**Planning application no: 2021/94552**

**Land at, Barnsley Road, Denby Dale, Huddersfield HD8 8TS.**

**Erection of 53 dwellings and associated works**

**Comments for inclusion in the public consultation relating to the above planning application.**

Appendix 6: Highways concerns adjacent site

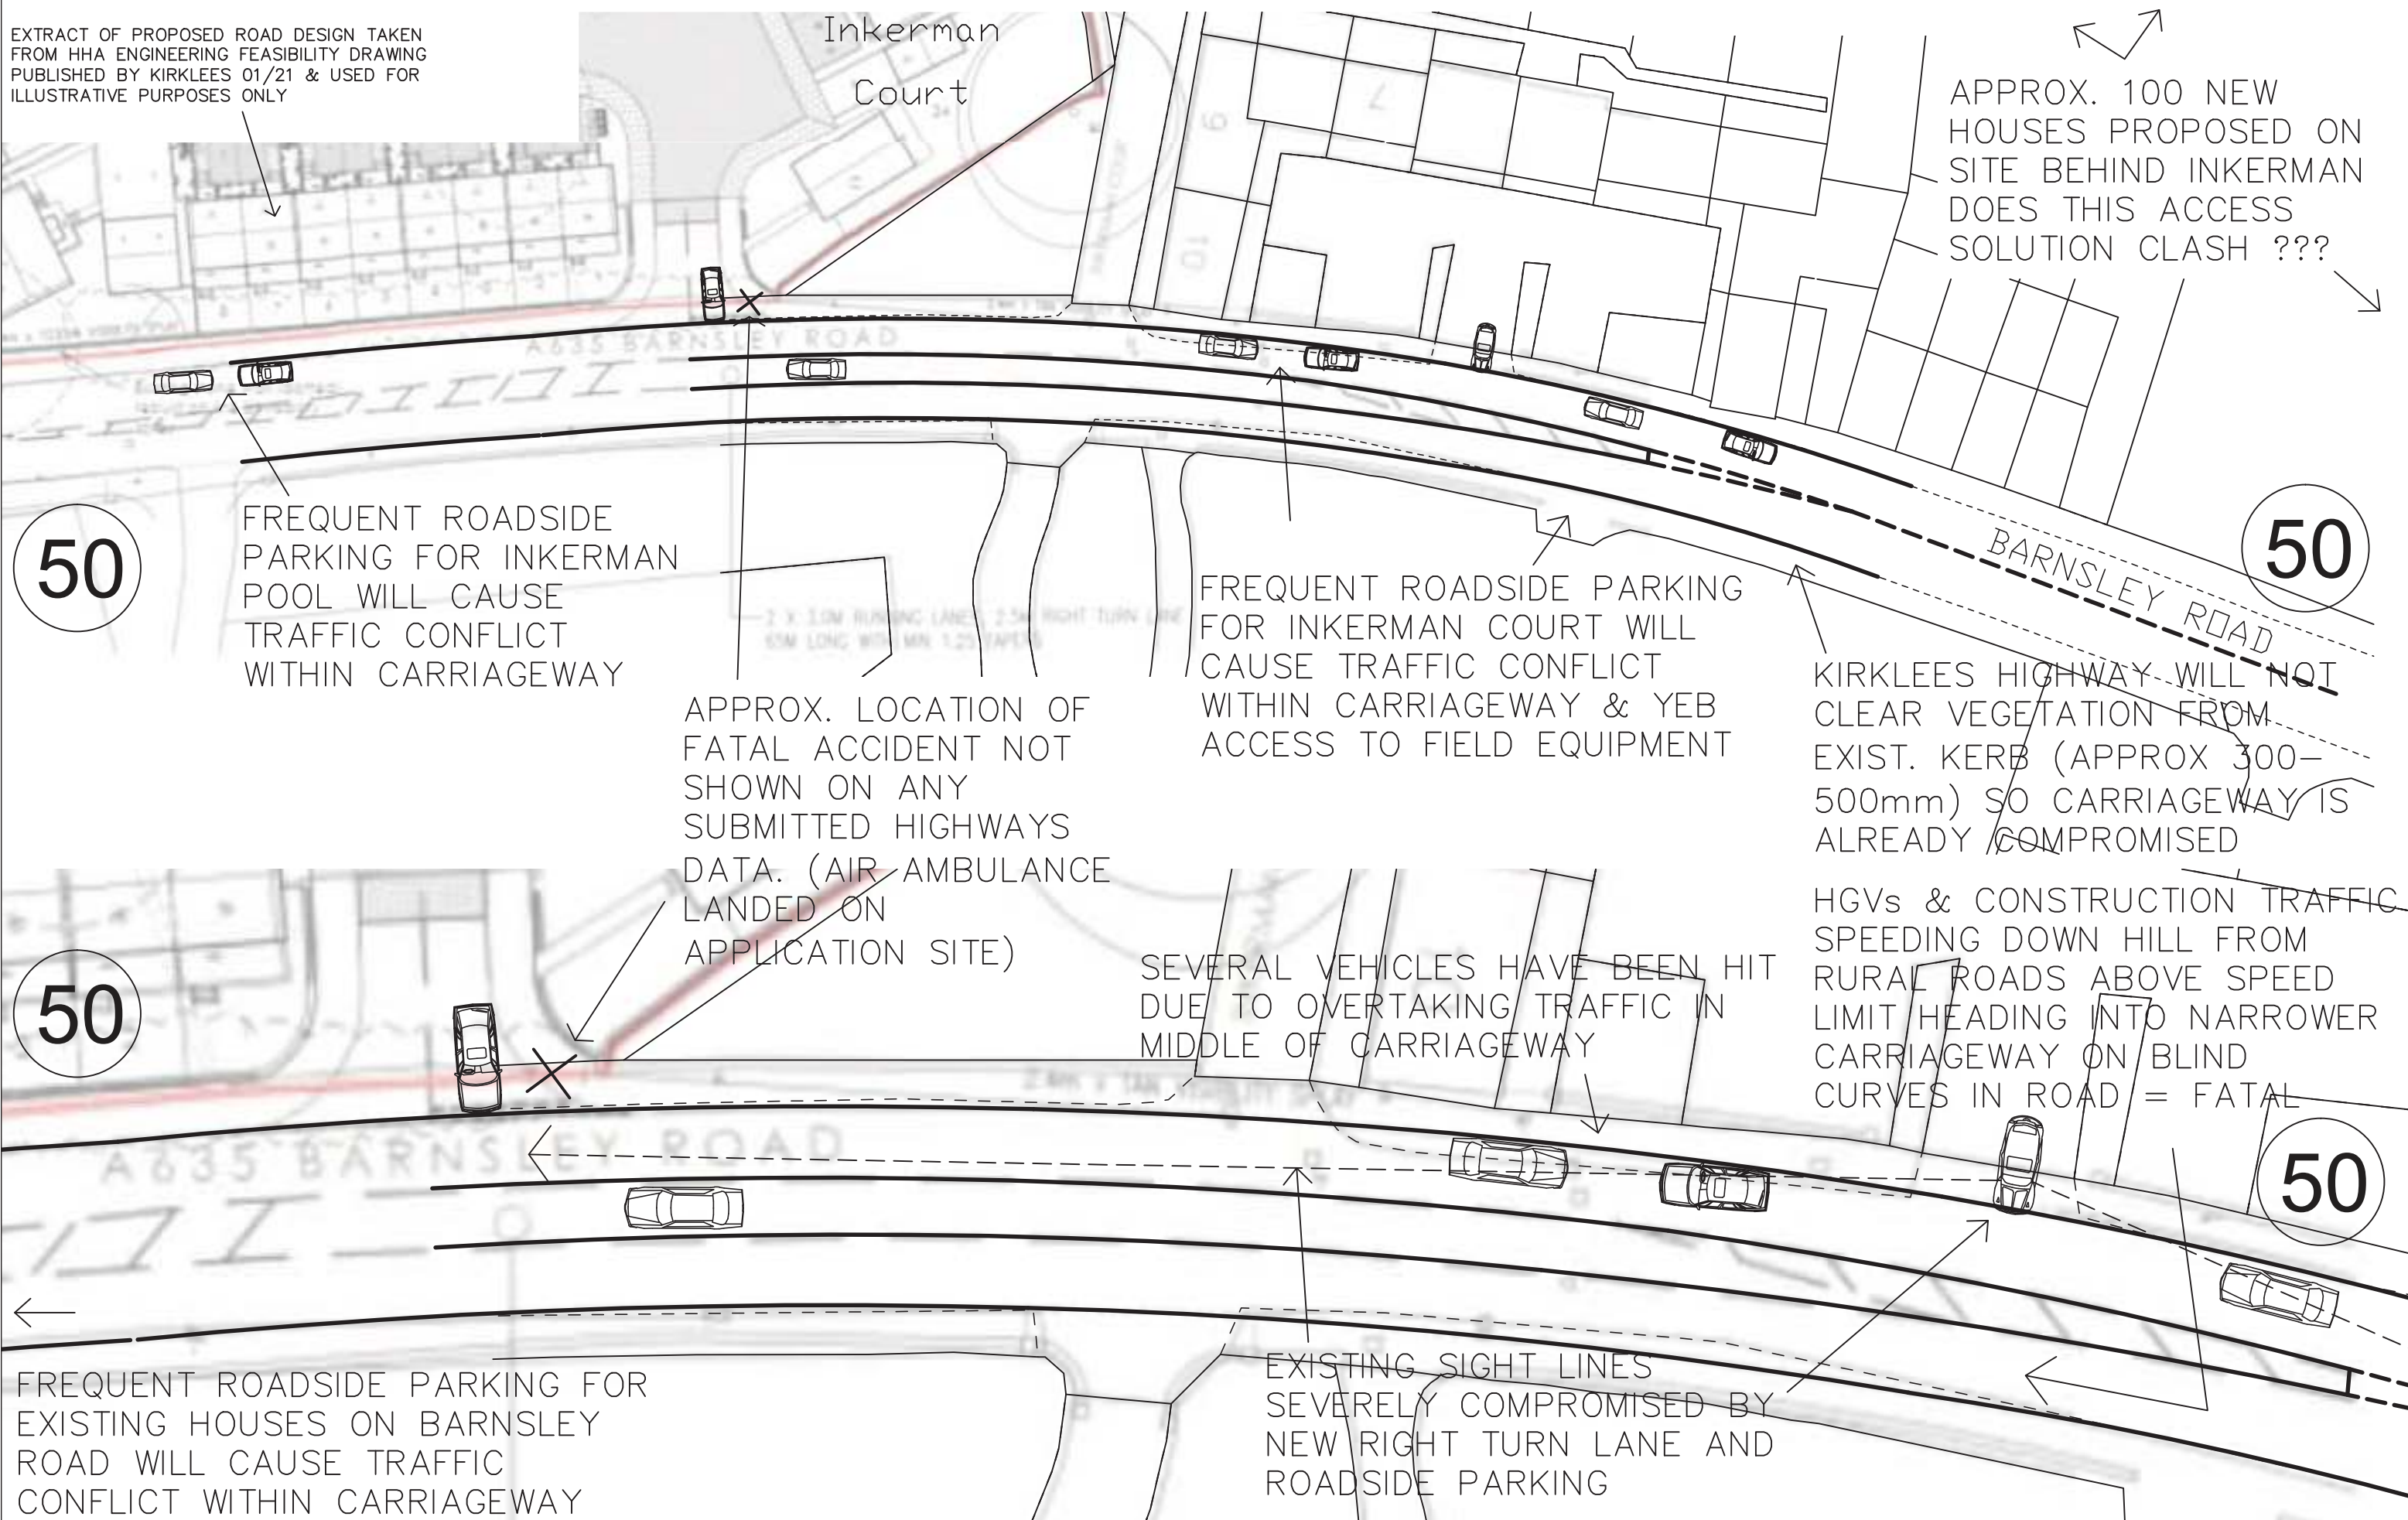
It should also be noted that very similar safety concerns were raised but not addressed by the Planning Process when the adjacent 34 unit planning approval (ref.2019-91836) and outline approval for 3 units directly opposite this Strata site (ref.2020-94314) was gained. Appendix 6 shows some of the primary concerns and it can be seen how this will affect the proposed access to the site under consideration.

Appendix 12: North Boundary retaining structure and materials issue

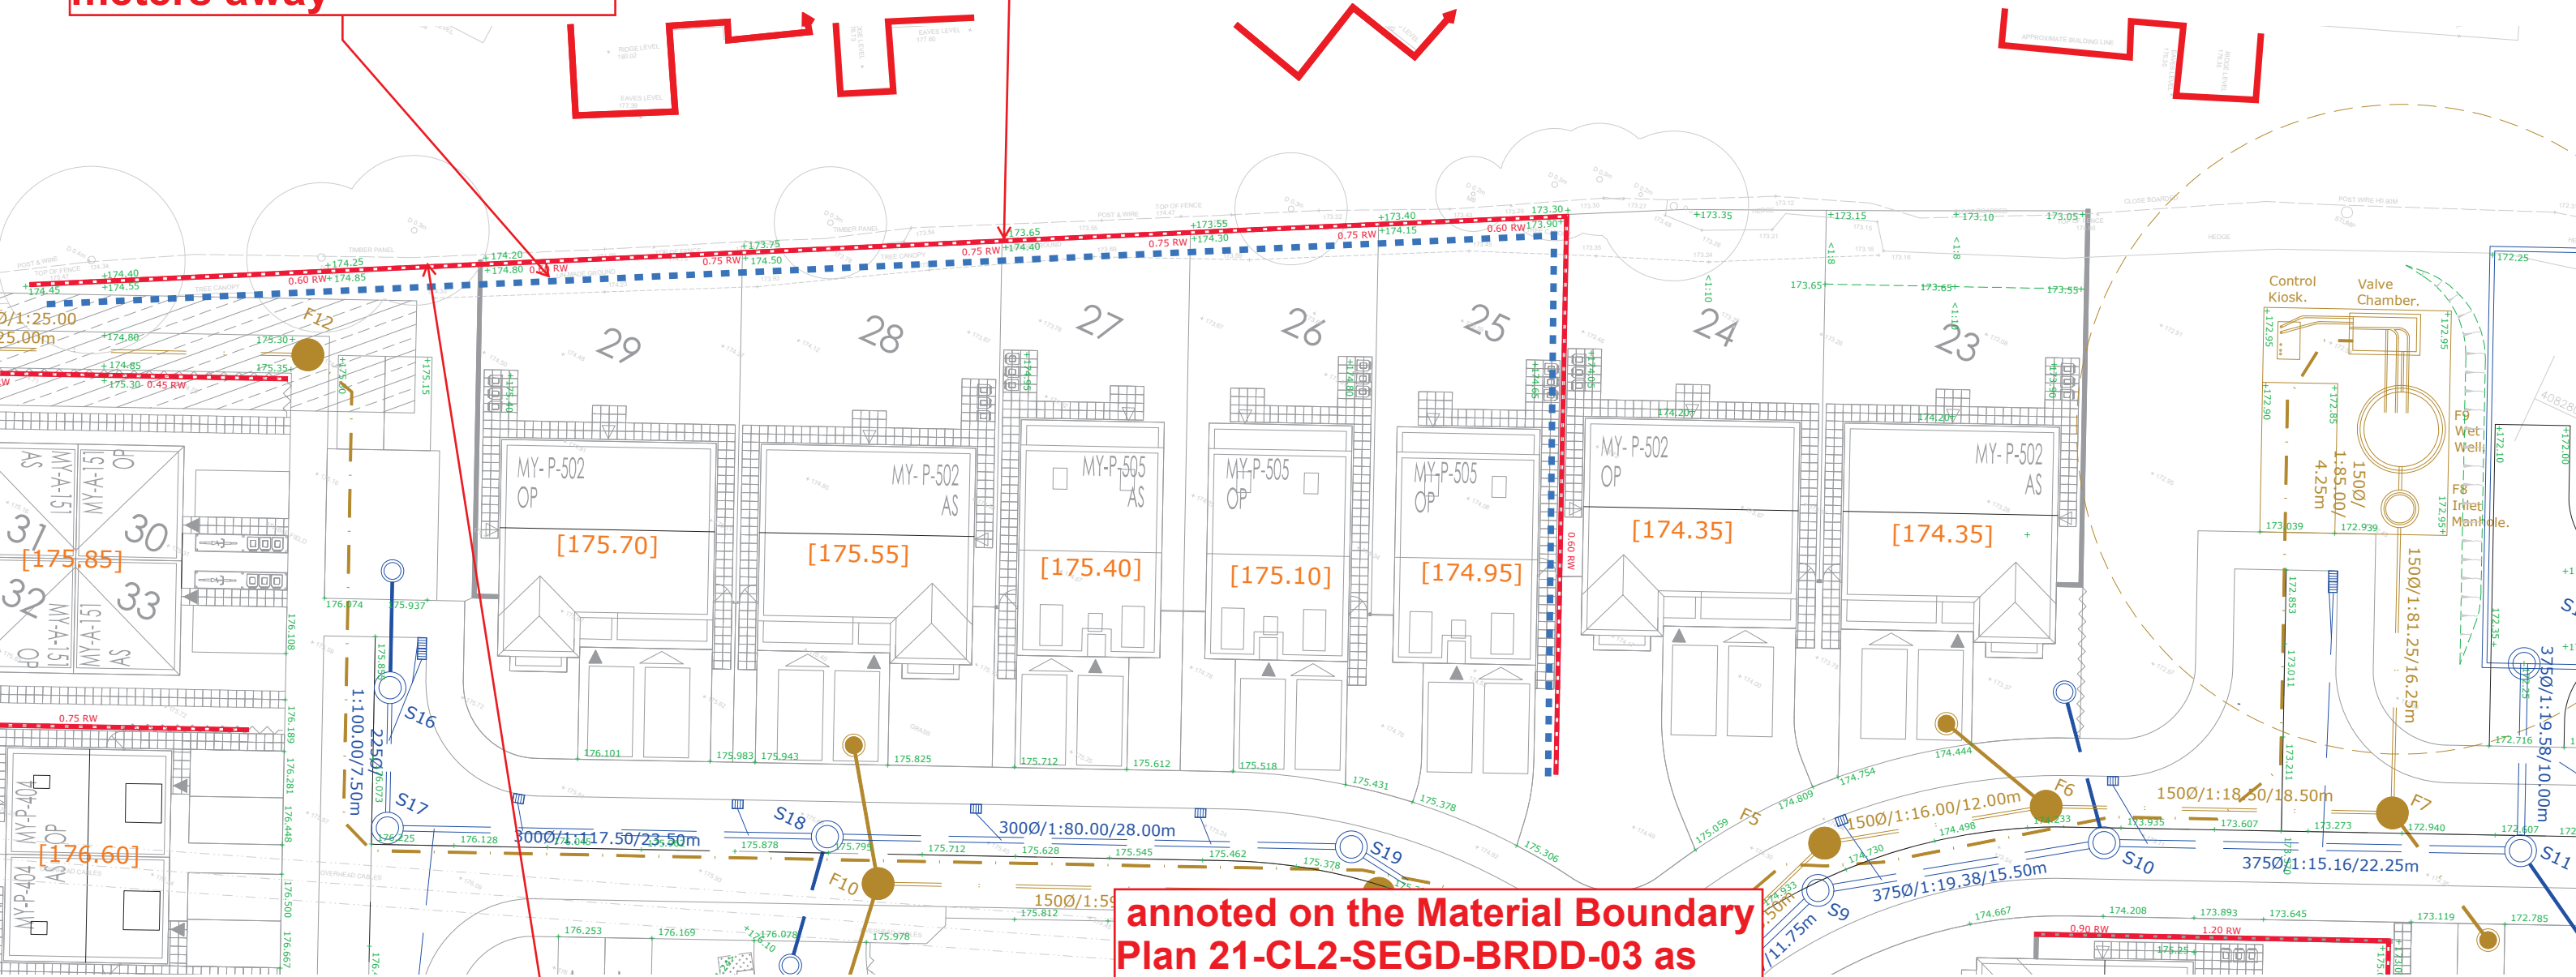
- b) Datums relating to the height of the proposed boundary fencing around the site (See Strata Material, Boundary & Surface Plan (ref 21-CL2-SEGD-BRDD-03 id908375) are missing and so the overlook impact cannot be assessed. There are also very few proposed levels indicated on the drawings provided and the application should not be determined without this critical information. We insist that this information is provided as a matter of urgency before the public consultation period ends. Specifically, finished floor levels at both ground, first and second floors are requested along with key levels to the boundaries as preliminary checks reveal the potential need for retaining structures and these are not indicated on the proposed layouts. See Appendix 12.
